SCOPING OPINION:

Proposed Stallingborough Combined Cycle Gas Turbine and Carbon Capture Plant

Case Reference: EN010161

21 March 2024

FIGURE NUMBER
 Figure 2C

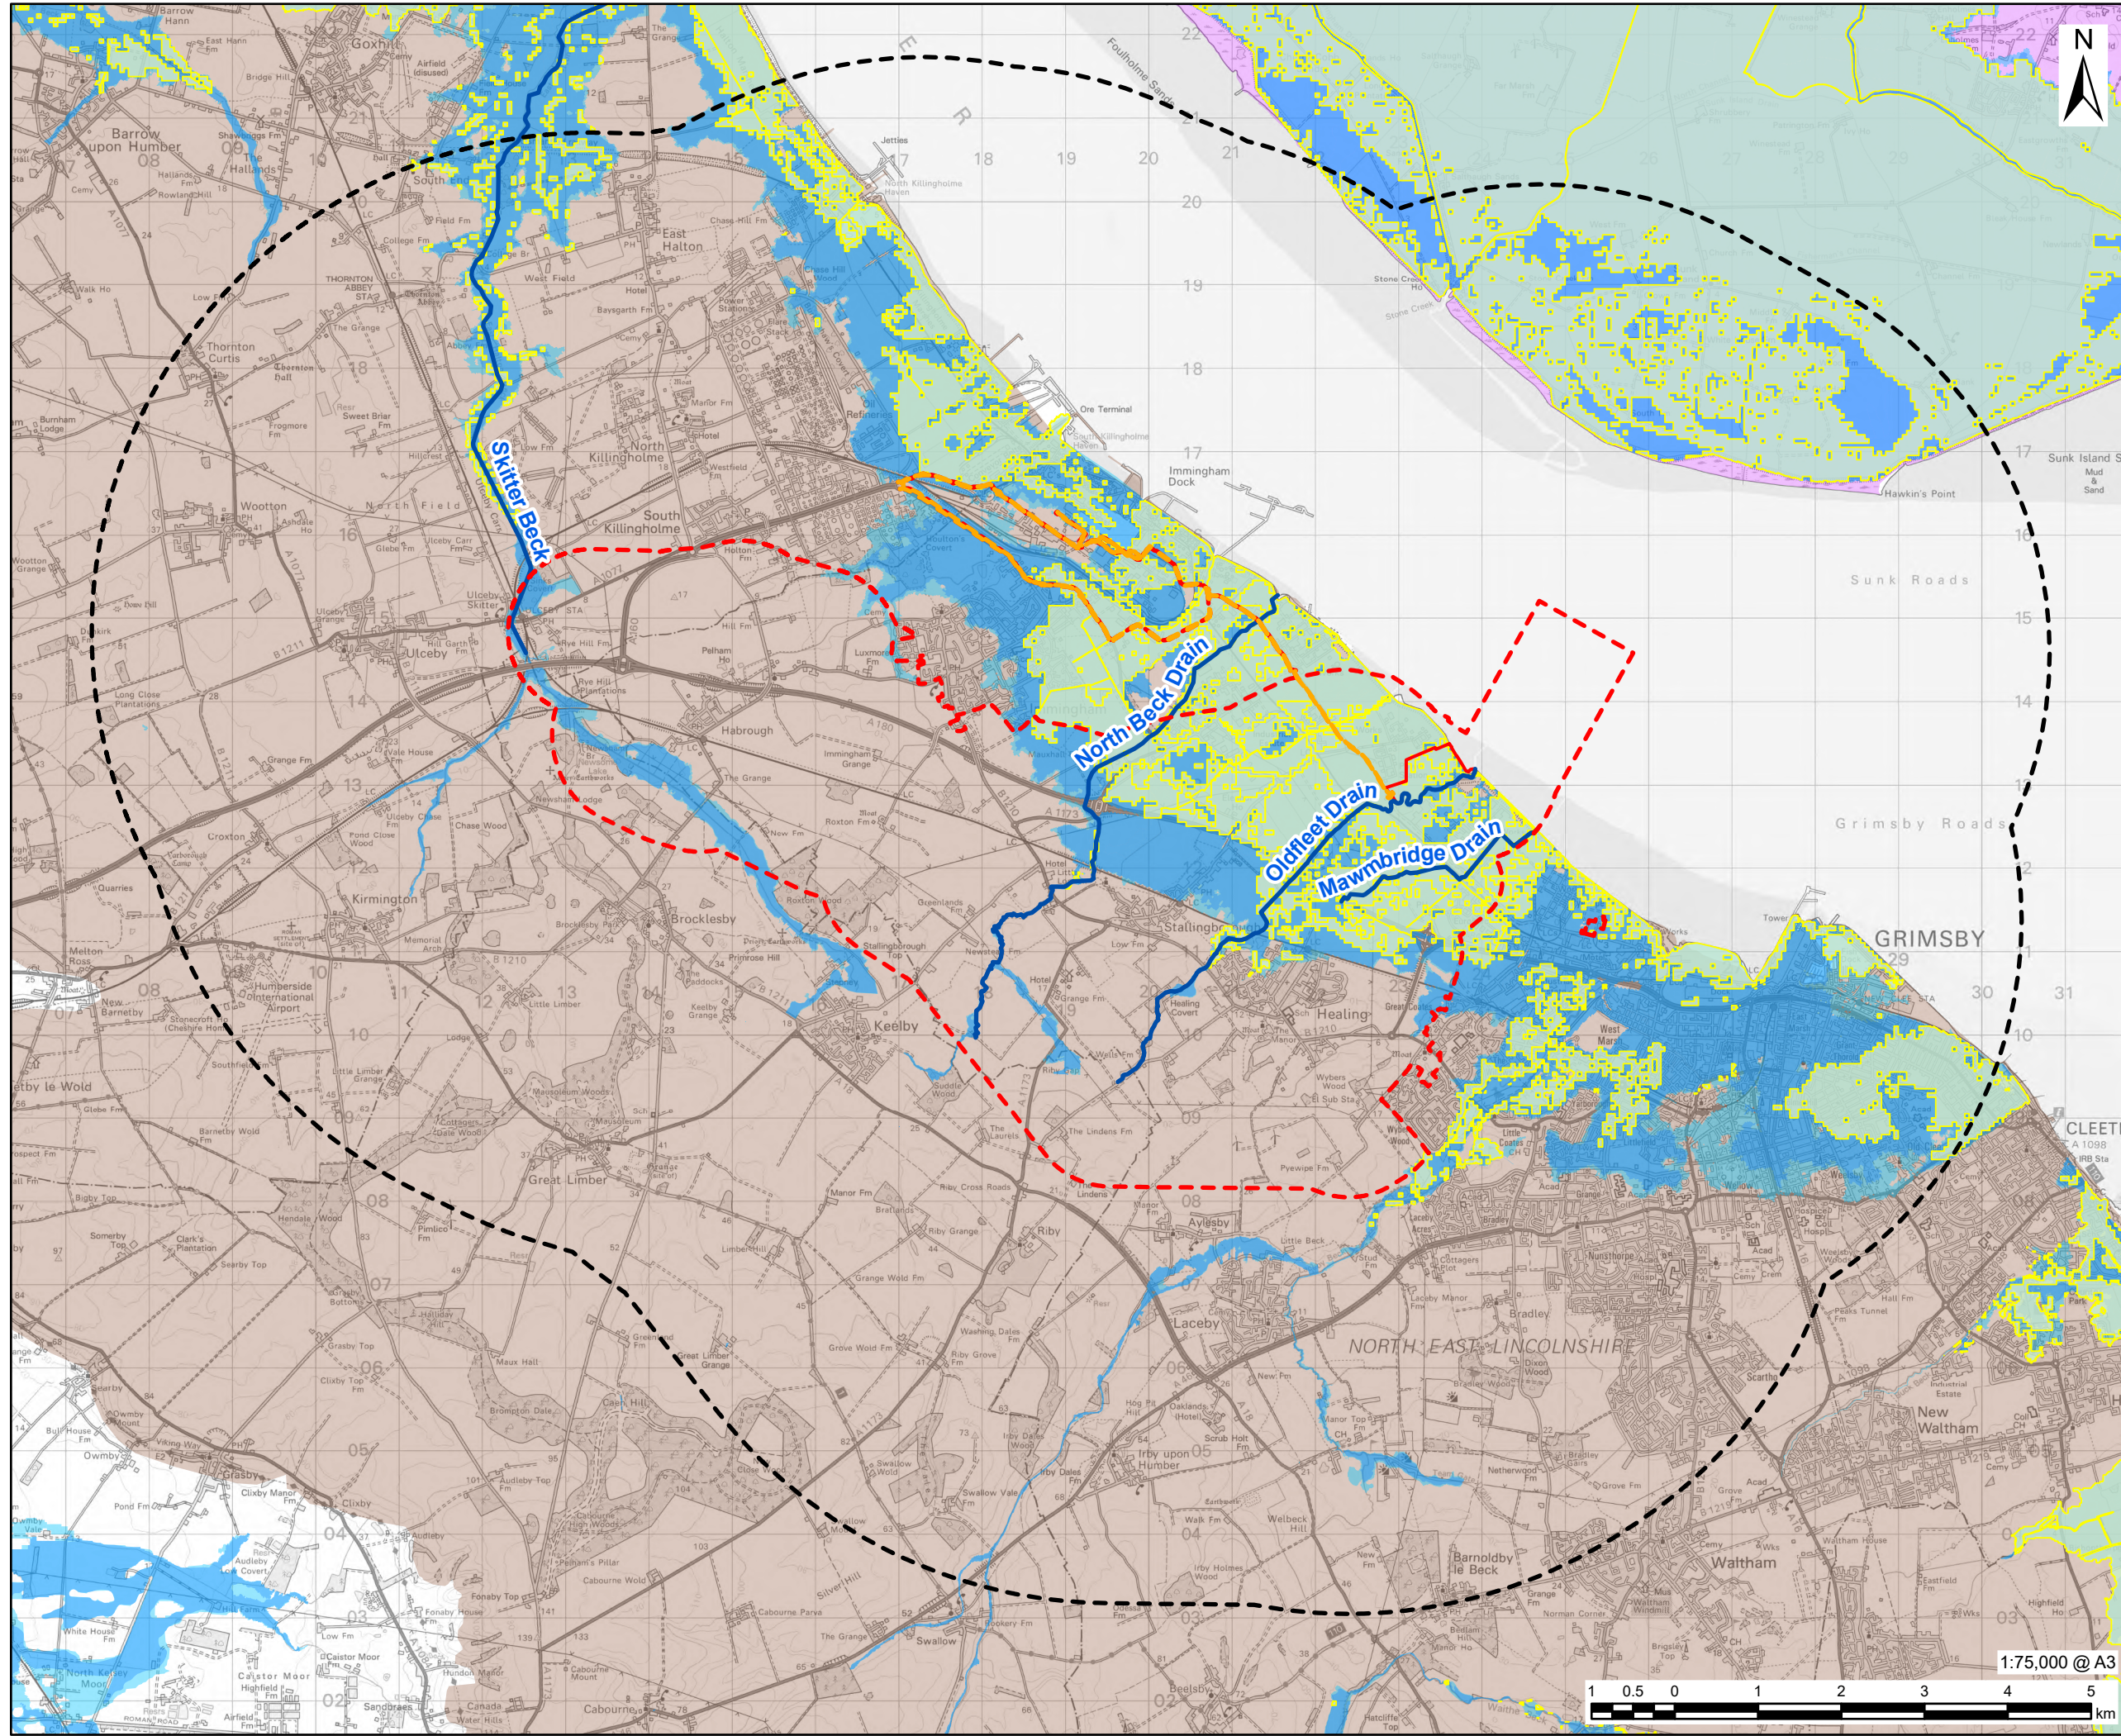
2.1.6	Para 2.4.9 and Figure 2C	Identification of receptors	New Cut Drain is identified in para 2.2.9 of the Report as a water receptor, along with Oldfleet Drain and North Beck Drain. However, no subsequent reference is made to New Cut Drain and it is not depicted on Figure 2C ('Water Receptors within 5km of the Site'). The figure identifies Mawmbridge Drain in addition to the above receptors, which is subsequently considered in the Report, so the Inspectorate

ID	Ref	Description	Inspectorate's comments
			<p>assumes that the reference to New Cut Drain is an error. A number of other water receptors that cross or are near to the wider Site are identified in Section 6.8 and Table 6.45 ('Watercourses Potentially Impacted by the Proposed Development') but are not included on Figure 2C. The New Beck Drain (Main River) is mentioned in paras 6.8.54 and 6.9.28 but omitted from Table 6.45. Care should be taken to ensure that potentially affected features are identified correctly and consistently in the ES and on accompanying figures.</p> <p>The Applicant's attention is drawn to the EA's comments (contained in Appendix 2 of this Opinion) in relation to other waterbodies that warrant consideration.</p>
